City of Albuquerque Stormwater Construction Site Inspection Report

ESC File No.	G14E097	Project Name:	Calle Cuarta Apts. & TH WO		
NPDES Id. No.	NMR100631/NMR100632	Location:	3525 4th St NW		
2/13/2025	Owner	Contractor			
Operator	Calle Cuarta LLLP, YES Calle Cuarta TH, LLC		Pavilion Construction		
Contact name & title	Page Ollice		Jared McCarn		
e-mail	pollice@yeshousing.org		jmccarn@pavilionconstruction.com		
Contact Phone #	505-923-9607		505-668-8854		
COA Inspector	Chancellor English		Start/End Time:	1030am	
Construction Phase:	verticals for apartments, utilities for townhomes				
Type of Inspection:	<input checked="" type="checkbox"/> Regular	<input type="checkbox"/> Storm Event	<input type="checkbox"/> Post Storm Event >0.25"	<input type="checkbox"/> 311/Complaint	<input type="checkbox"/> Follow Up
Weather at time of inspection?	Clear		Temperature: ~	45	
Estimated date of last storm 0.25" or greater	11/7/2024

REVISION #	REVISION ITEM	DATE
1	FINAL STABILIZATION & NOT NOTES UPDATED	12/7/23

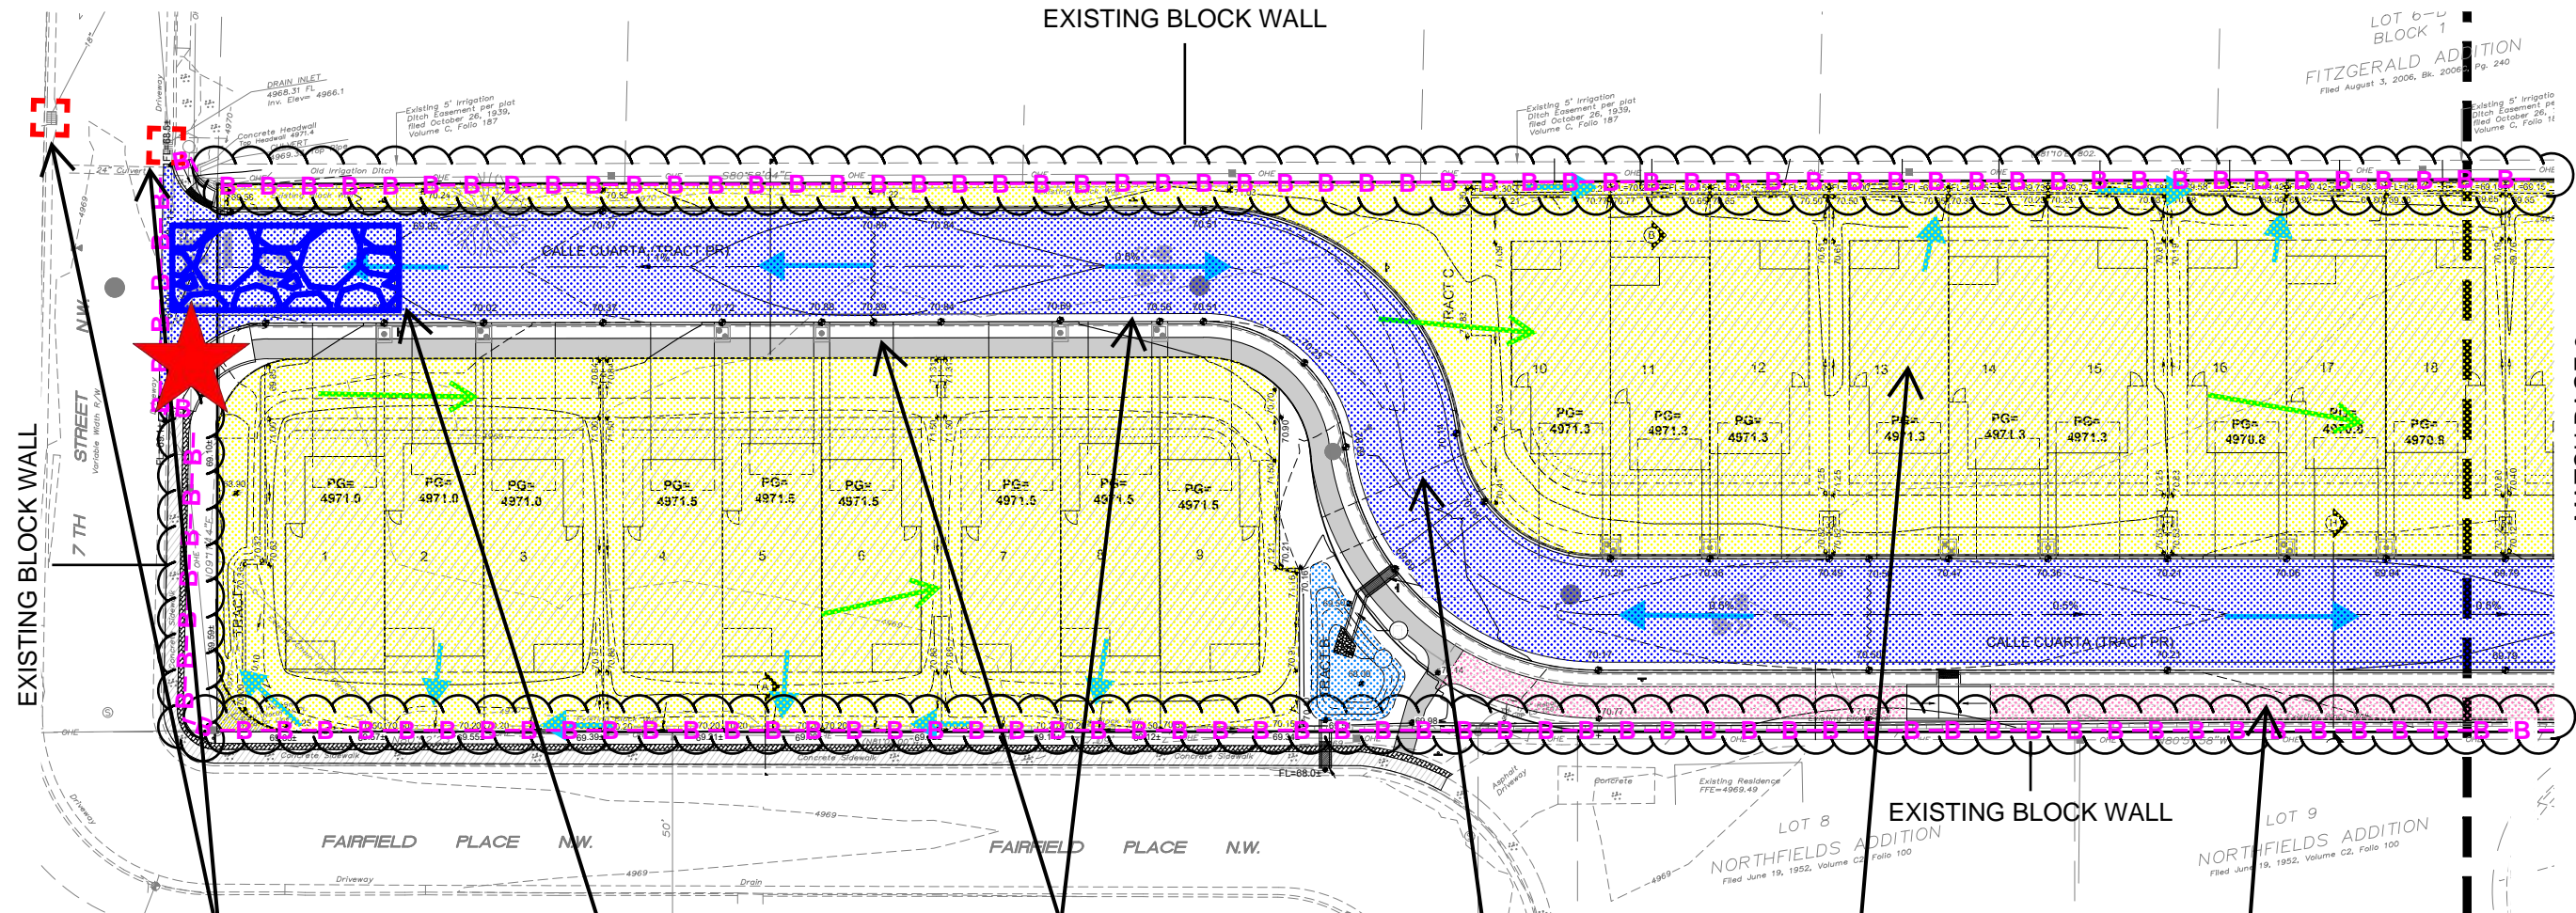
Item Number	Deficiency/ Corrective Action				
1	BMPs - The perimeter silt fence on the north side along Fitzgerald Rd has collapsed in several sections and needs maintenance in violation of CGP Part 2.1.4. Required mitigation: Ensure all stormwater controls are maintained and remain in effective operating condition during permit coverage and are protected from activities that would reduce their effectiveness per CGP Part 2.1.4.
